Rezoning Transportation Analysis

Petition Number: 2025-025

General Location Identifier: 21902107

SITE PLAN, RZP-2025-025

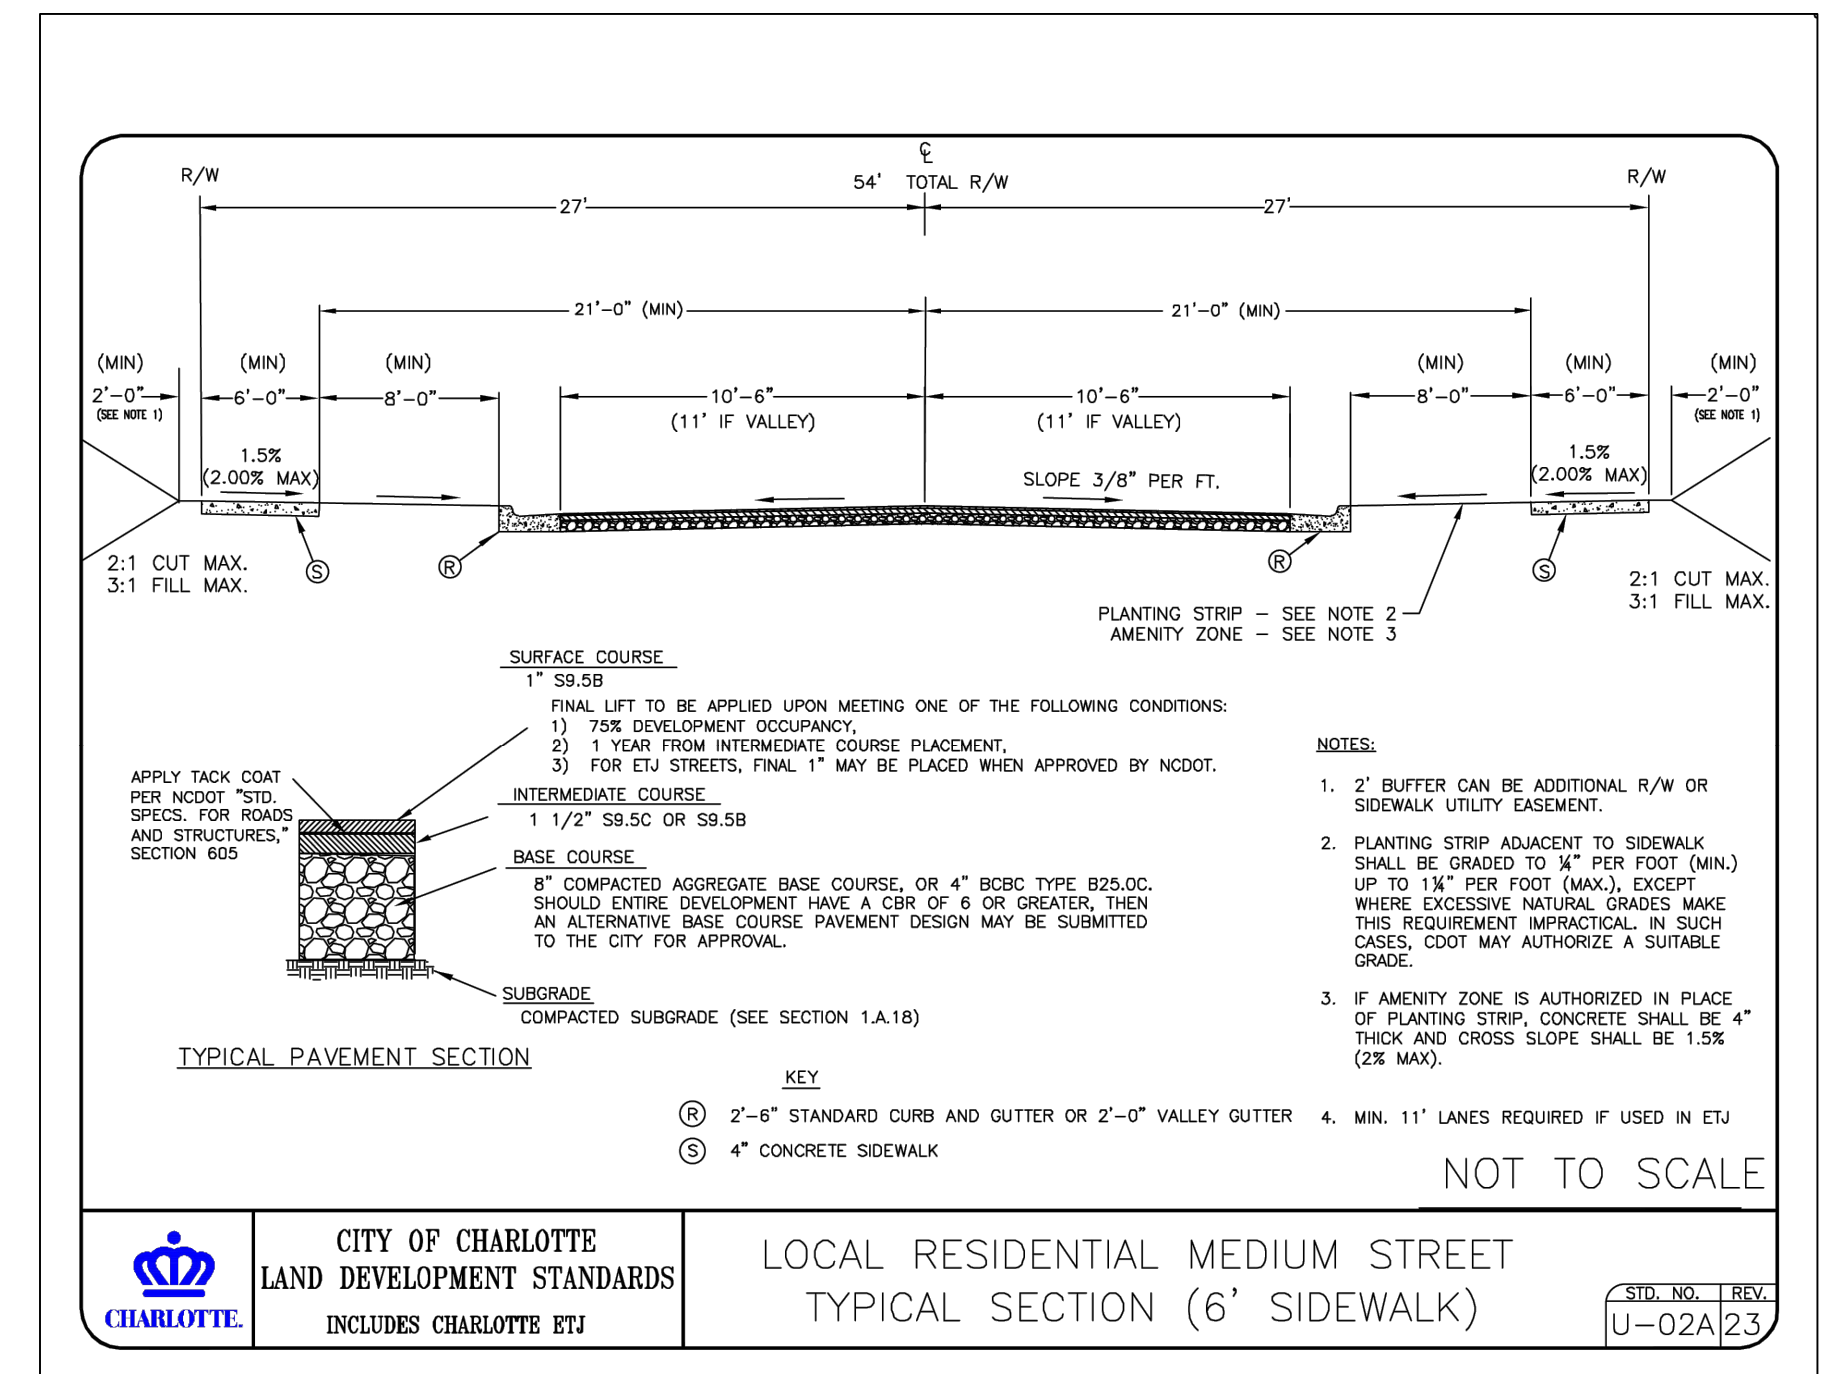
a. ~~Loughlin Lane:~~ Location of future back of curb and gutter is 13'.

~~Local Residential Medium Street Typical Section (6' Sidewalk) CLDSM: U-02A~~

~~Label and dimension the curb and gutter from the centerline for each road on the site plan.~~

3. ~~Revise site plan and conditional note(s) to commit to dedicate 27' right-of-way from the road centerline. The site plan shall label and dimension the right of way from the road centerline.~~

4. ~~Revise site plan to show stub street instead of the oversized residential cul-de-sac with raised planter island detail per CLDSM 11.21.~~

Outstanding Comment 6.25.25: ~~Remove oversized residential cul-de-sac with raised planter island from design. Install standard stub end streets with adequate turnaround for future connections.~~
